**ADC Planning Consultation
Response from the Historic Buildings Adviser**

Application Number	AB/97/14/L & AB/96/14/HH
Address	37 King Street, Arundel
Description	Internal alterations and extension to rear.
Case Officer	Damian Sullivan
Site Visit

EXISTING GROUND FLOOR PLAN

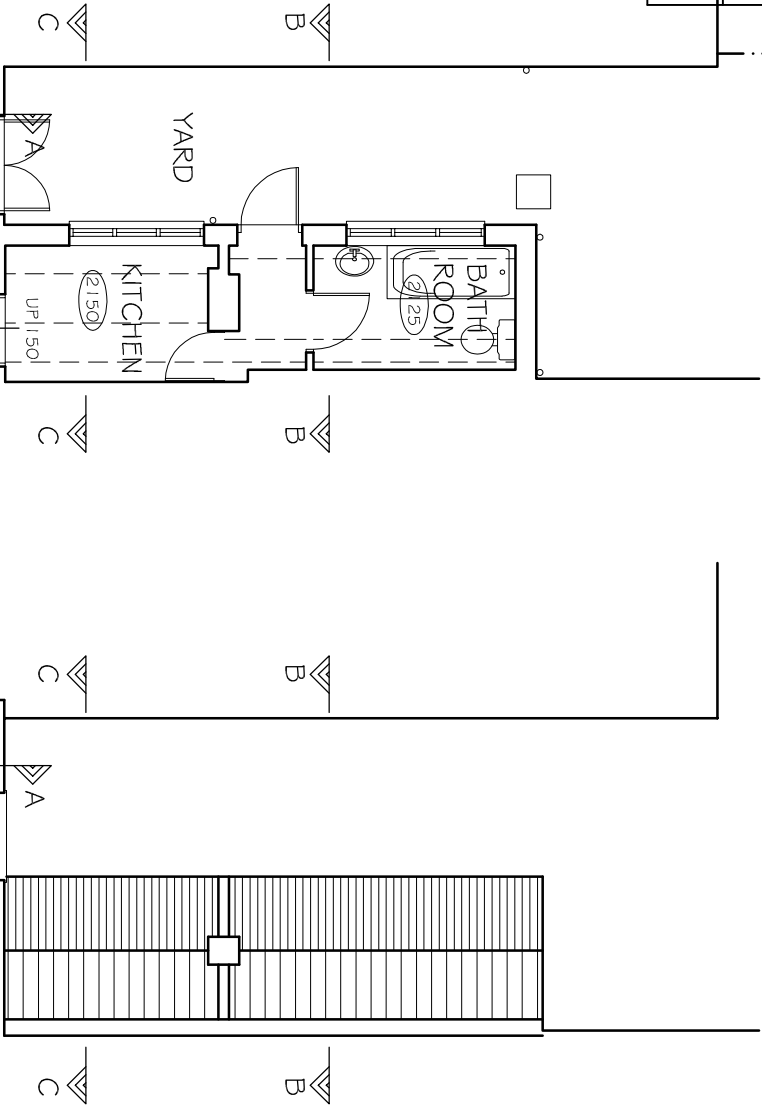
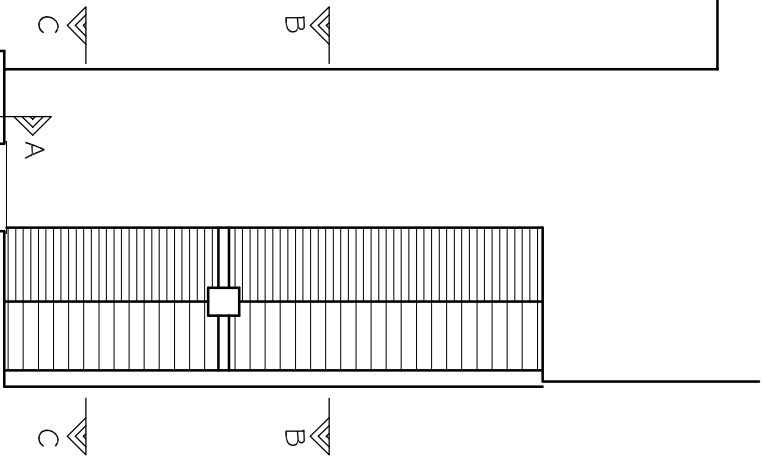
The staircase appears to be in its historic location and as such maintains the historic plan of the listed building. Previous applications from 1975 and 1977 would seem to confirm this. Historic plans and layouts are important to the special interest of listed buildings and should be preserved in accordance with the PPS5 Practice Guidance.

DWG NO 342/02
REV. D

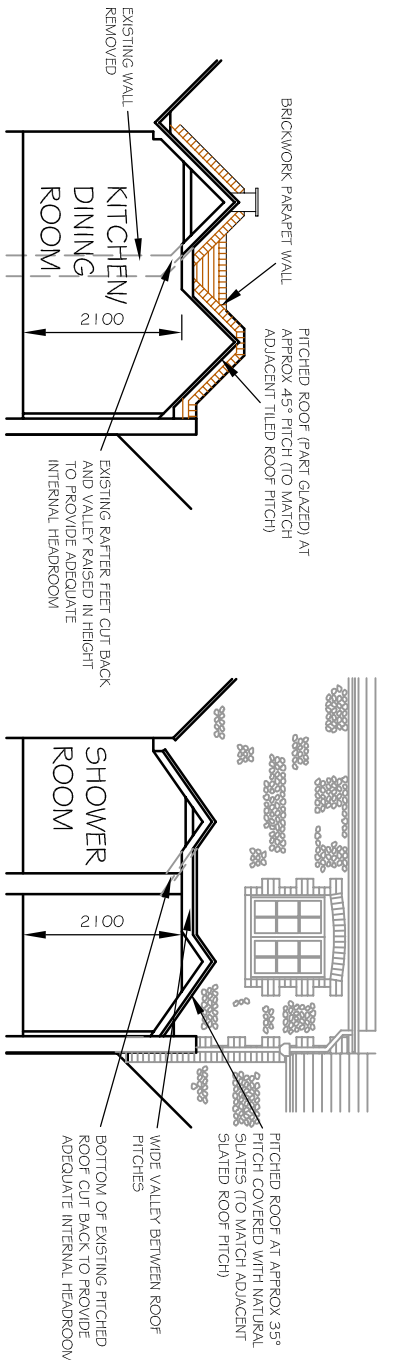
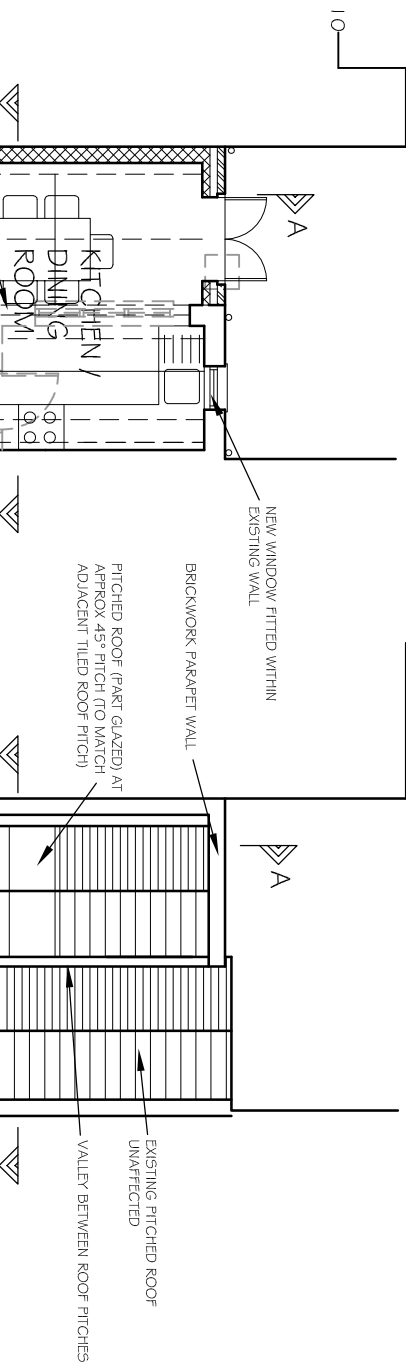
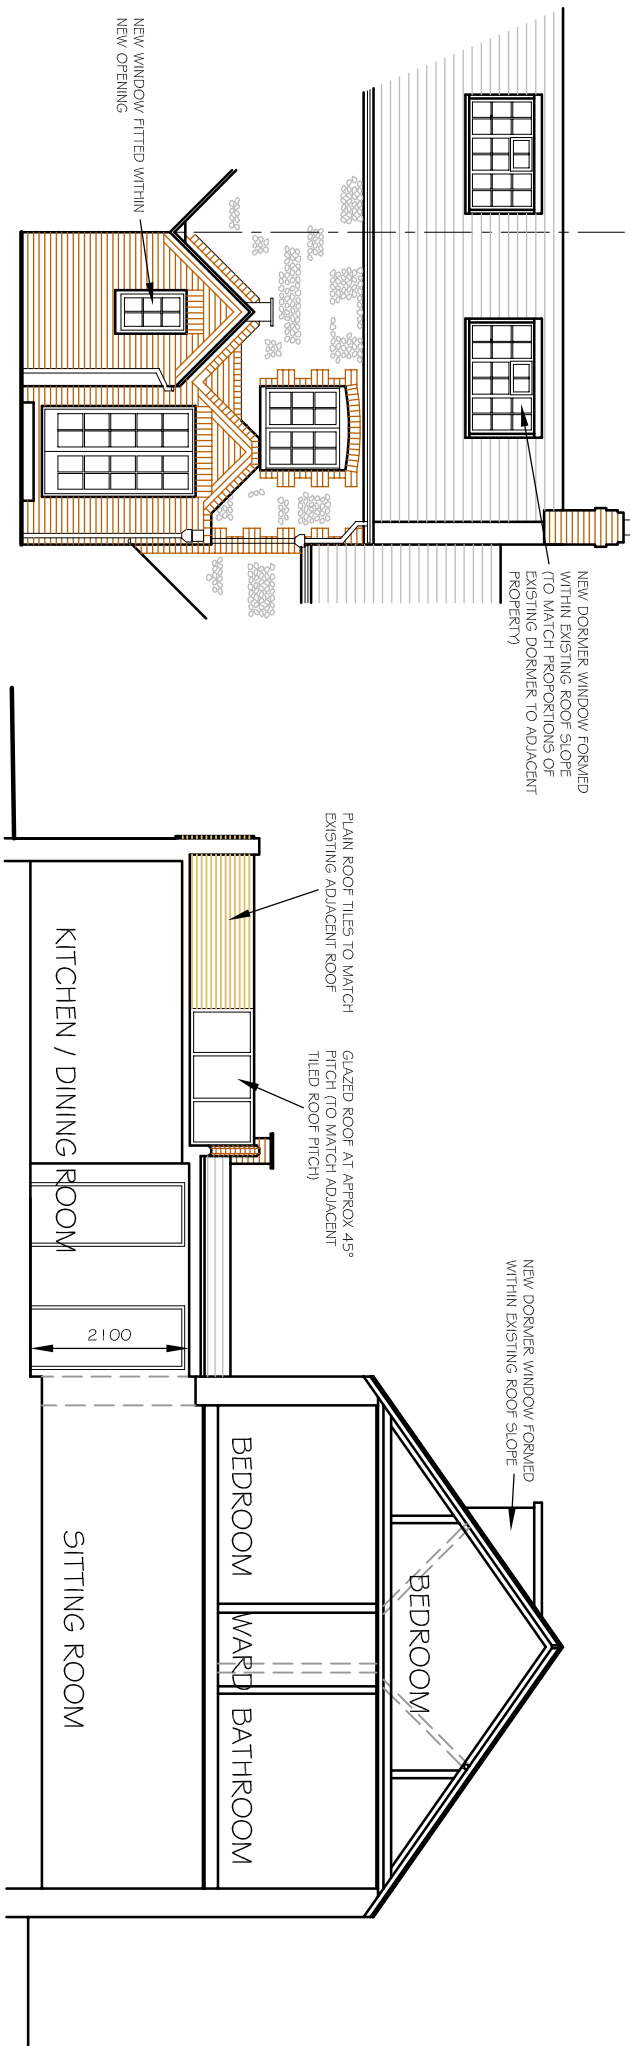
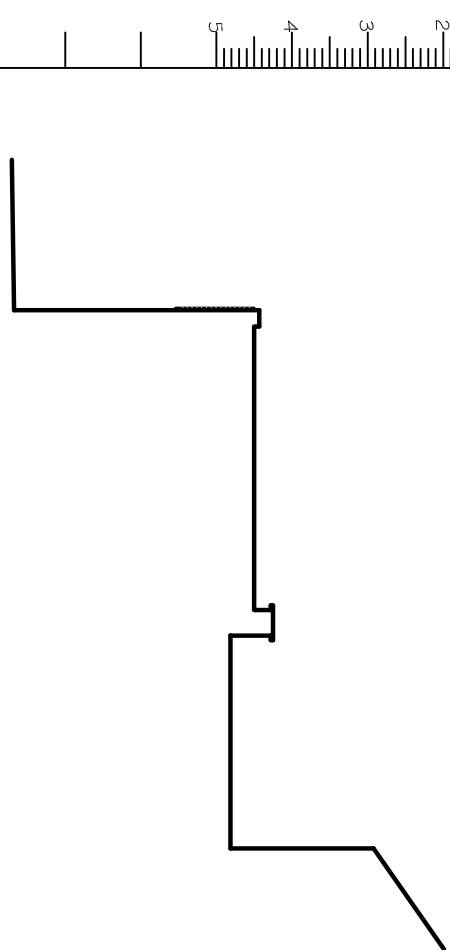
The addition to the rear, whilst likely to be acceptable in principle, is not as yet convincing. The new roof form and rear elevation seems overly complex. The proposed dormer window is also over-sized and should not include a top opening vent.
